# KITTITAS COUNTY FIRE MARSHAL'S OFFICE

Fire Marshal comments  
Easton Travel Center  
SE-26-00001  
Bradley Gasawski, Project Planner

SCALE GRAPHIC	EASTON TRAVEL CENTER	SHEET
DRAWN BY: LVE	PARCEL SITE PLAN	1
CHECKED BY: LVE	EASTON, WA	
SURVEYED BY:	DATE: FEBRUARY 13, 2024

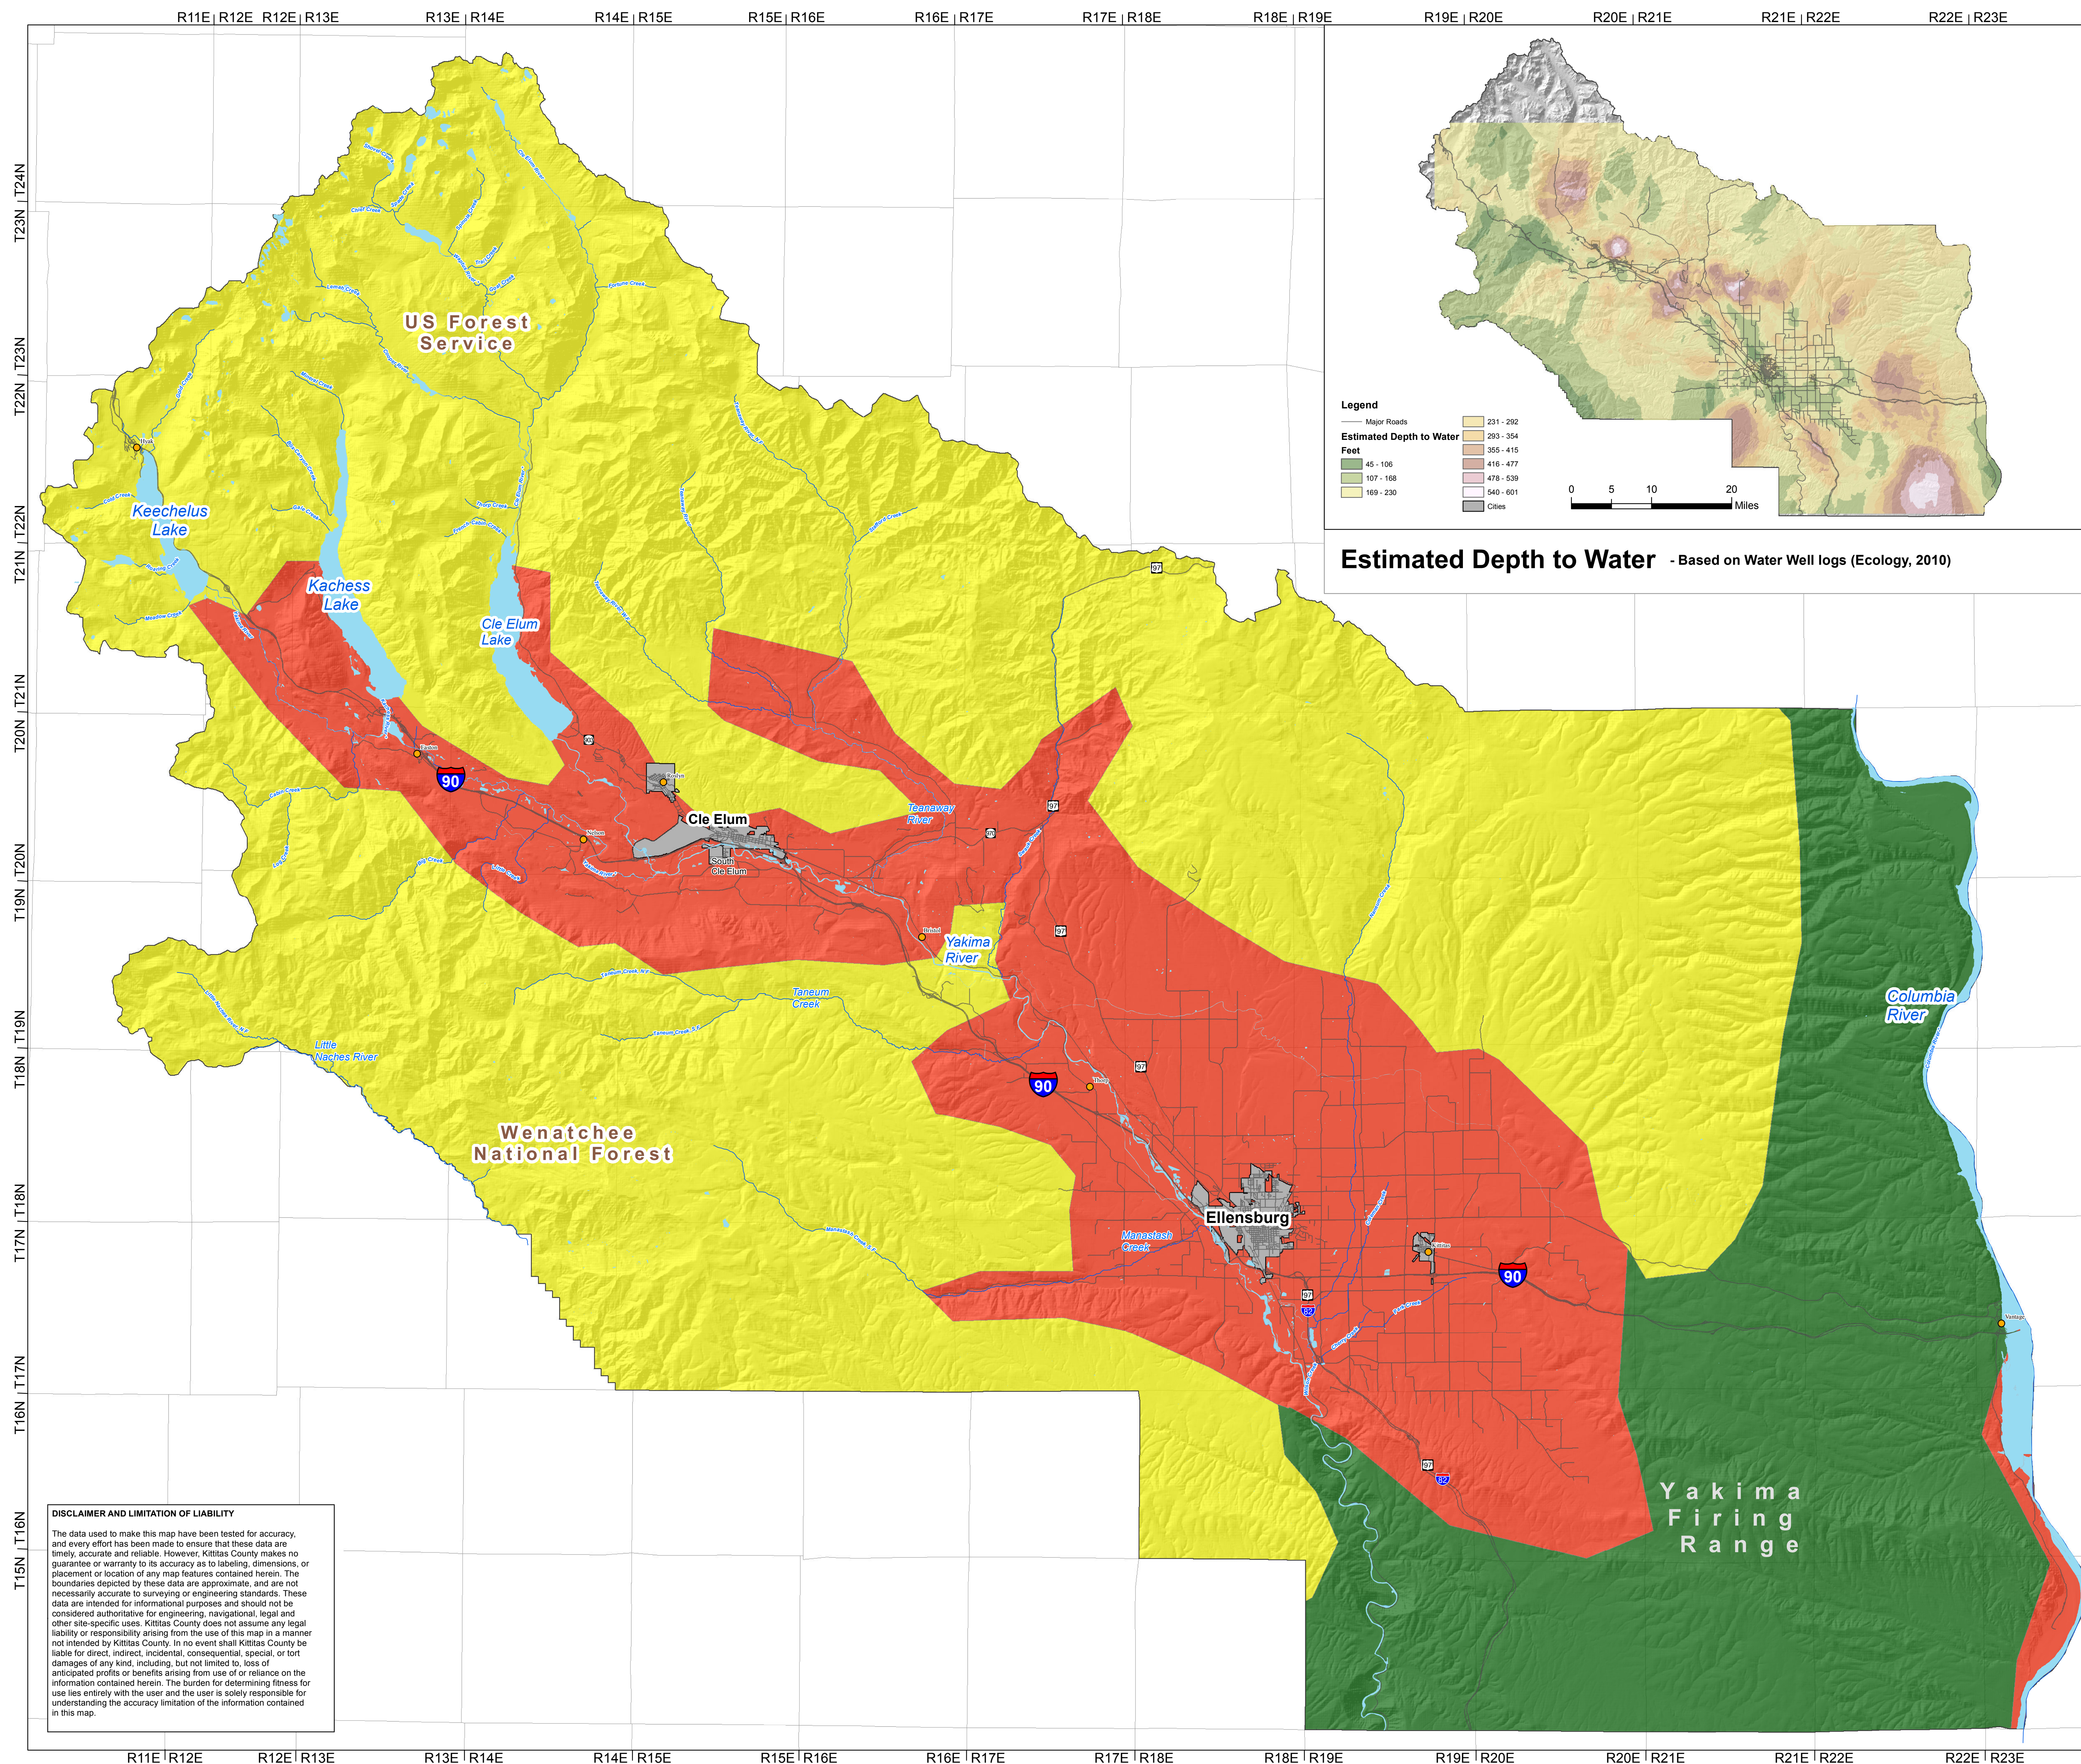
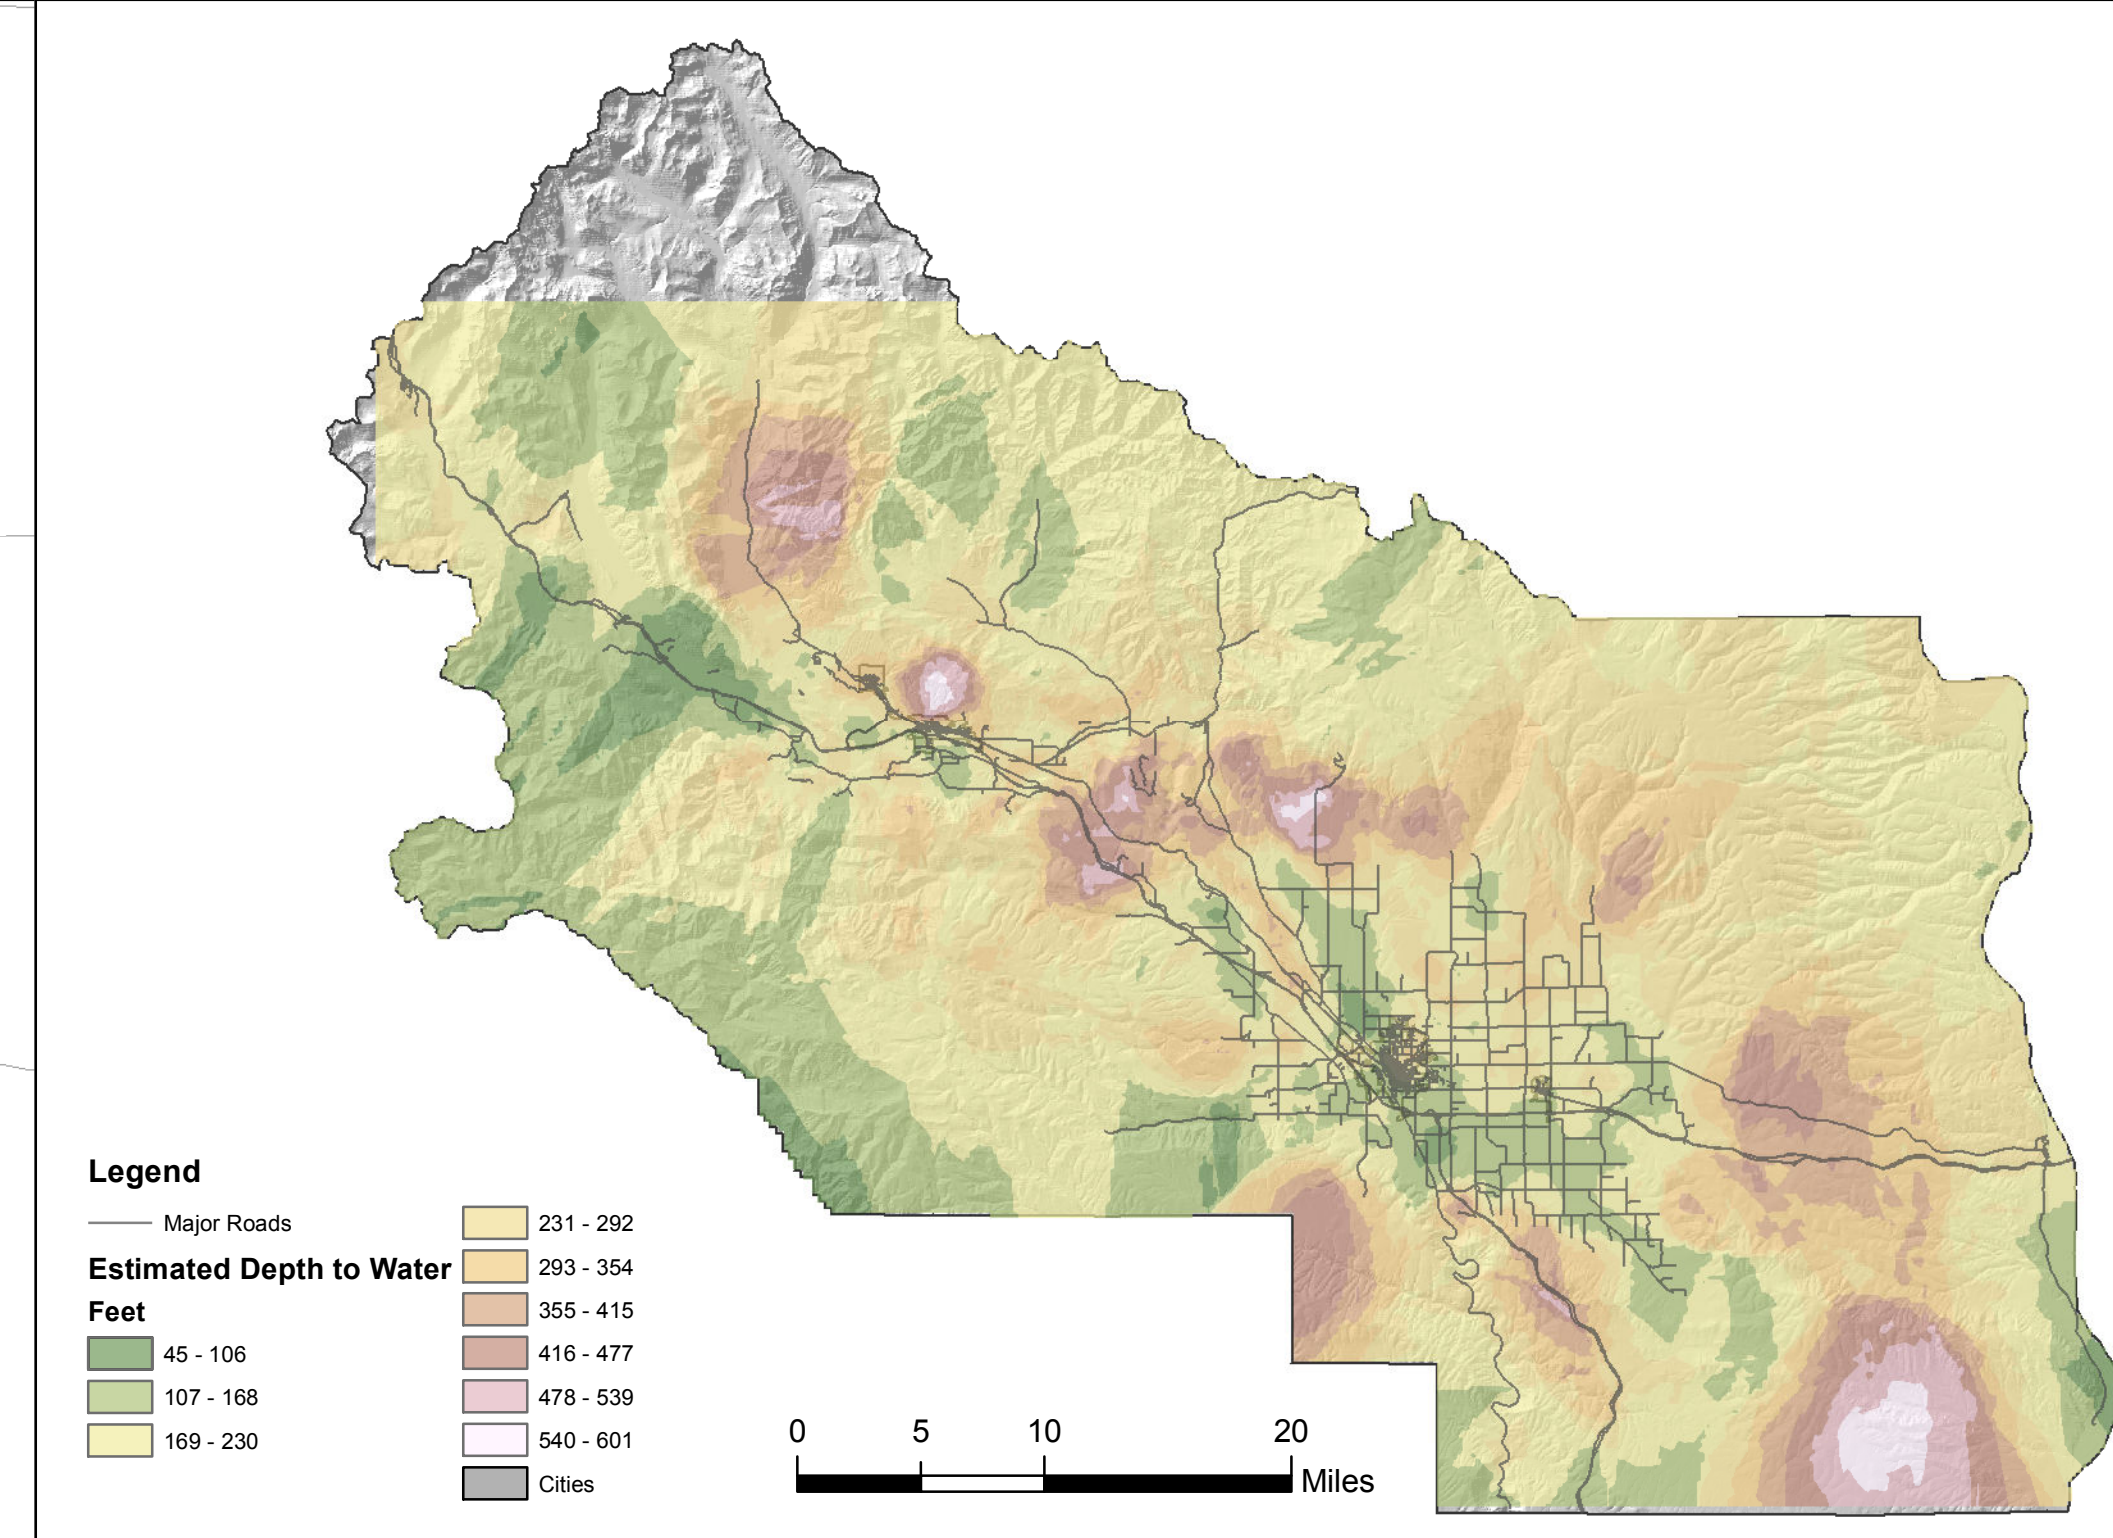
Fire hydrants are required for this application. Either the indicated number or the spacing of the fire hydrants is inadequate. Provide a minimum of 3 fire hydrants such that the average spacing between hydrants does not exceed 450 feet and such that no portion of the building exterior is in excess of 300 feet from a fire hydrant as measured along approved fire apparatus access roads.

Fire apparatus access is required for this application. The roadways and maneuvering areas as indicated in the application adequately provide required fire apparatus access. Provide fire apparatus access roads with an unobstructed width of not less than 20 feet, an unobstructed vertical clearance of not less than 13.5 feet, with an all-weather driving surface and capable of supporting the imposed loads of fire apparatus. Access roads shall extend to within 150 feet of all portions of the facility and all portions of the exterior walls of the first story of the building.

Approved fire apparatus turnarounds are required for this project. The indicated provisions for turning around fire apparatus are adequate.
